From: Debbie Marriage [REDACTED]
Sent: 30 June 2022 15:13
To: Anita Gardner <Anita.Gardner@arun.gov.uk>
Subject: Re: LU/145/22/PL Wellesley Court, Littlehampton

I have now had an opportunity to review your application and I am writing to you to request withdrawal of the application prior to refusal for the following reasons:

Proposed Site

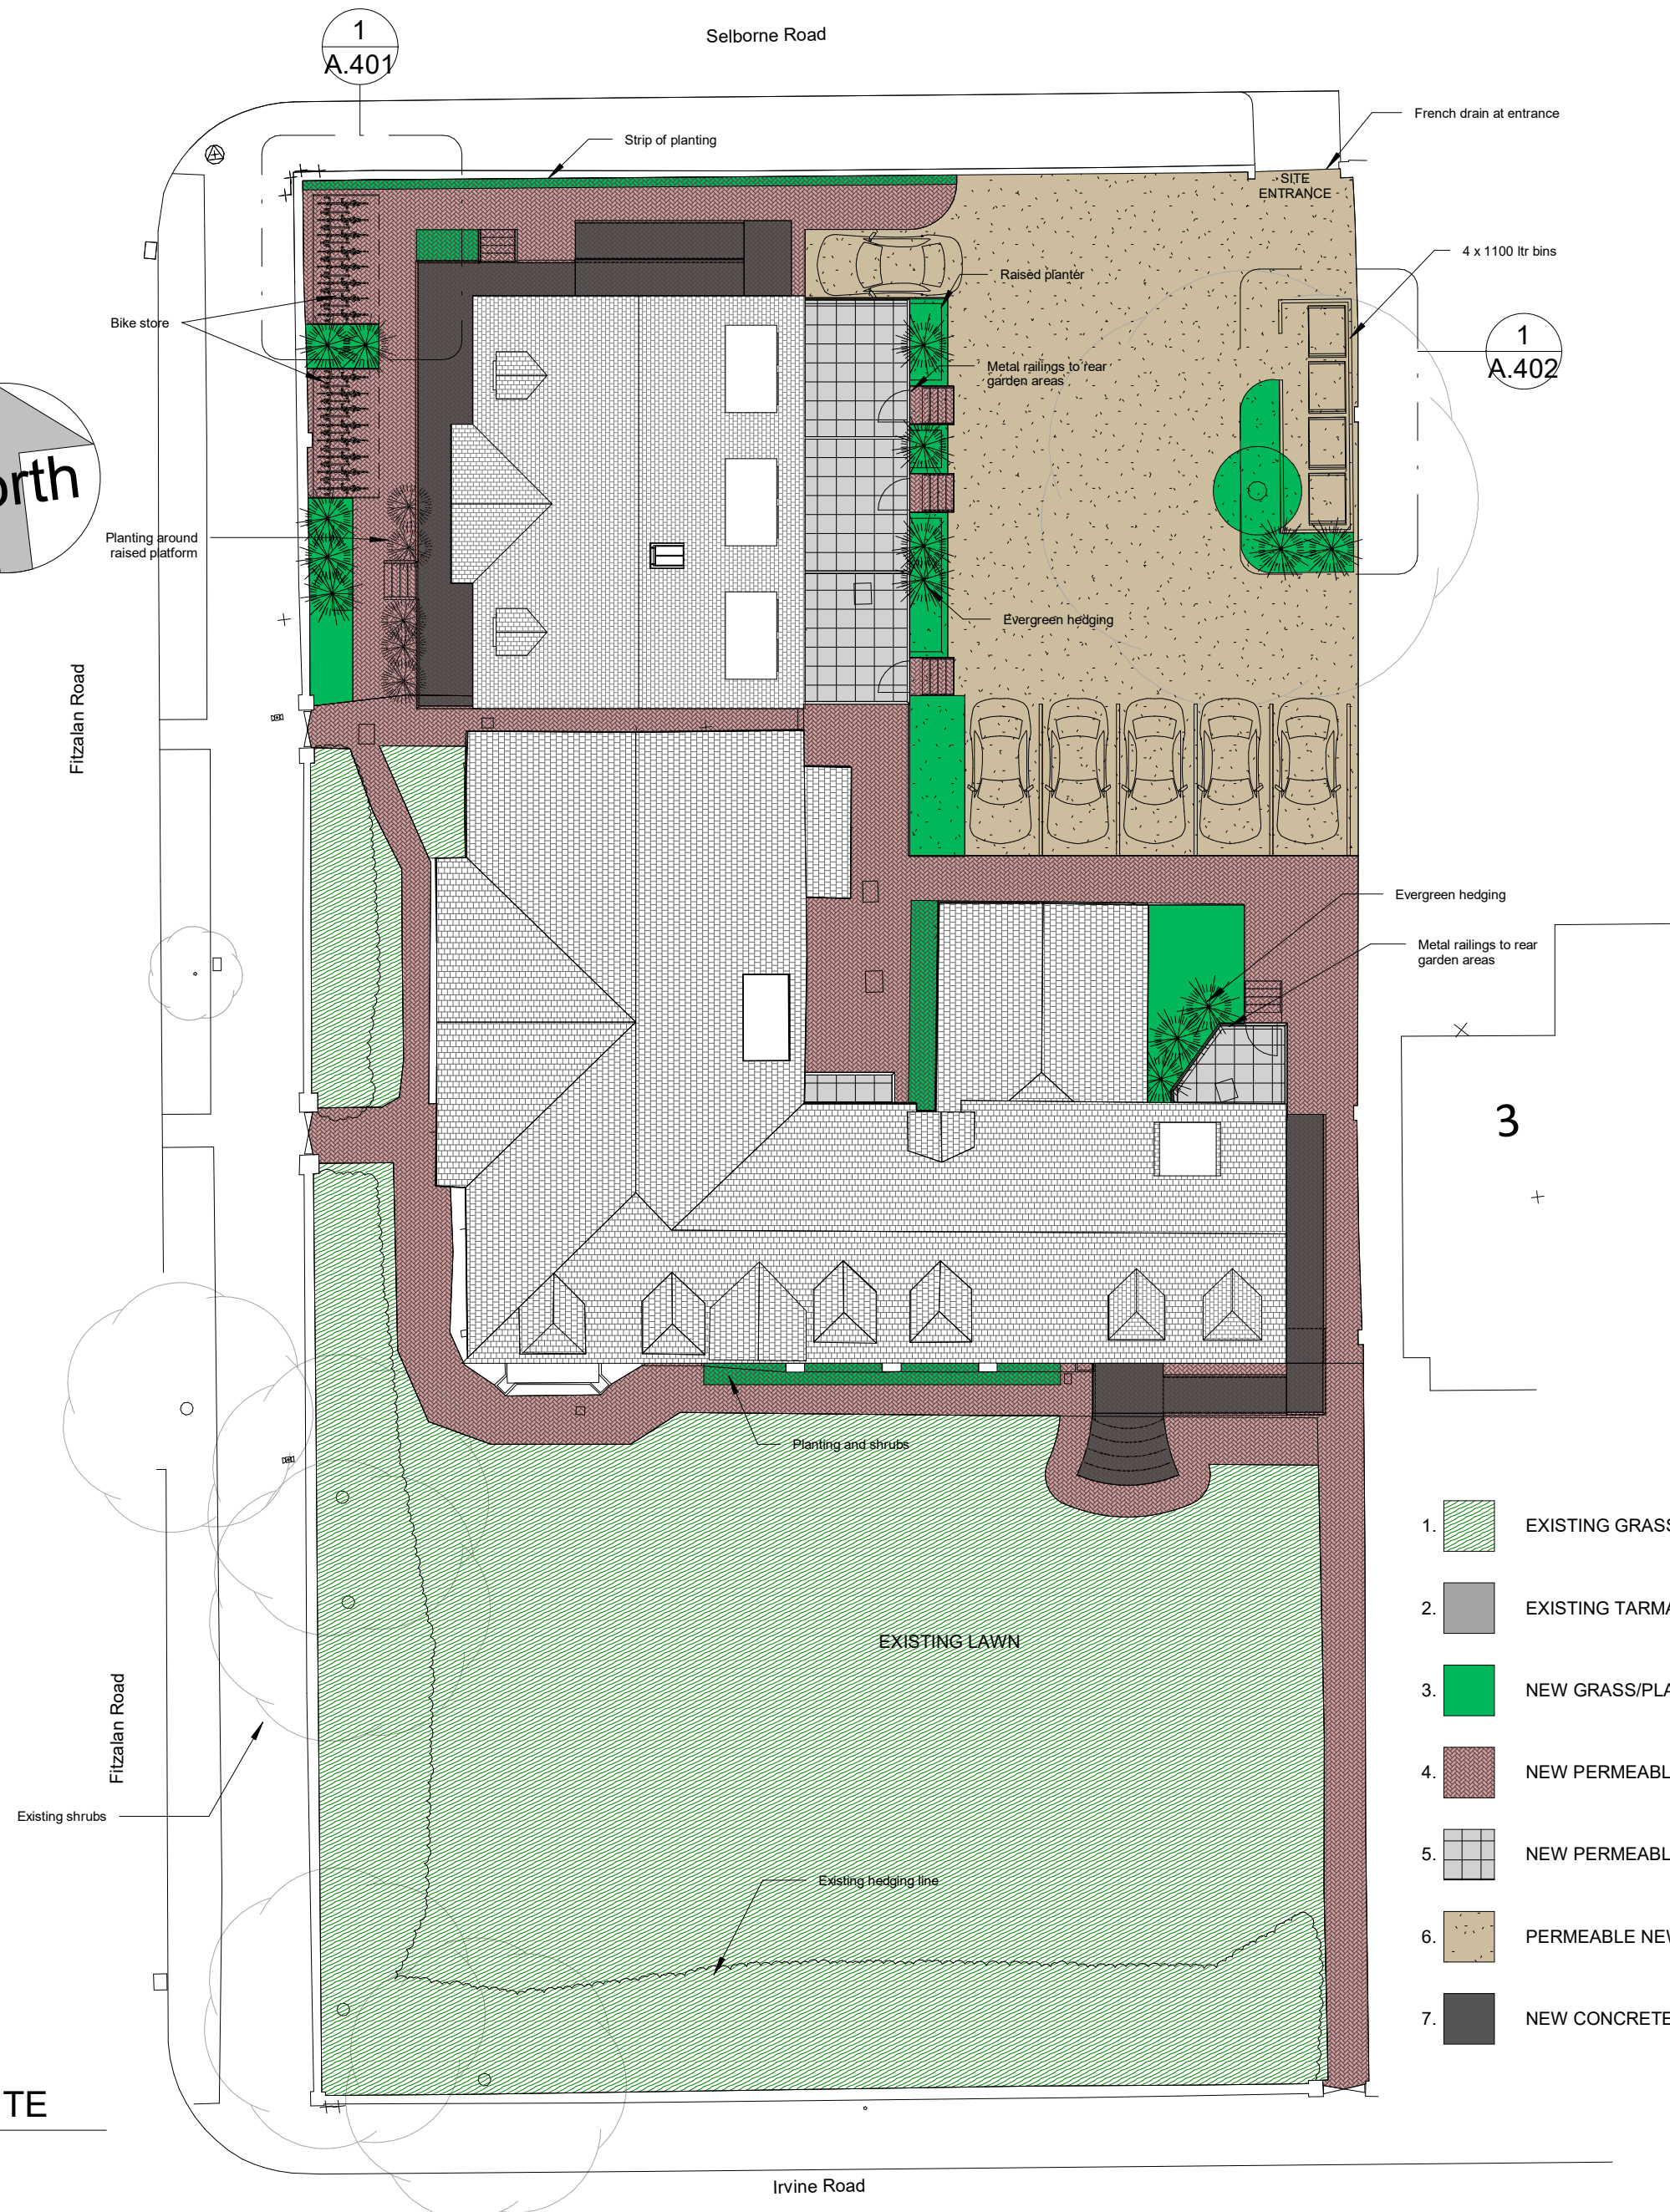
Further, I am of the view that the development proposed is too close and too high in respect of its relationship with the Selborne Road frontage to the north and would be dominant in respect of its impact on the street scene and out of keeping with the character of the area. The loss of existing car parking and under provision of car parking for the proposed development is also an issue. Whilst some relaxation of the parking requirements would be acceptable in this sustainable location the number of spaces provided is not high enough.
